Addendum No. 1

RE: Contract # C204279
WBS # 2020CPT.05.14.10921.1 Etc.
STATE FUNDED
Wake County
1 Section Of NC-39, US-264A and US-64 And 82
Sections of Secondary Roads

January 15, 2019 Letting

**TYPICAL SECTION 19**  
 WIDENING S9.5B  
 MAP NO. 85 (EAGLE ROCK RD)

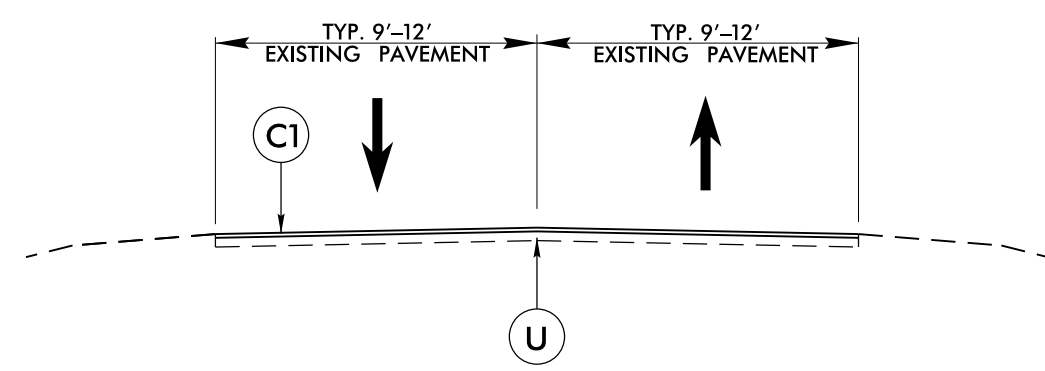
The Contractor is hereby notified that the 5.5" of Asphalt Concrete Base Course, Type B25.0C placed in the areas of 2' widening (Typical 19) will not be required to meet the usual compaction requirements of the *Standard Specifications* and *QMS Manual*. Thoroughly compact the mixture to the highest degree achievable by the use of hand tampers, hand operated mechanical tampers, small rollers or other approved methods.
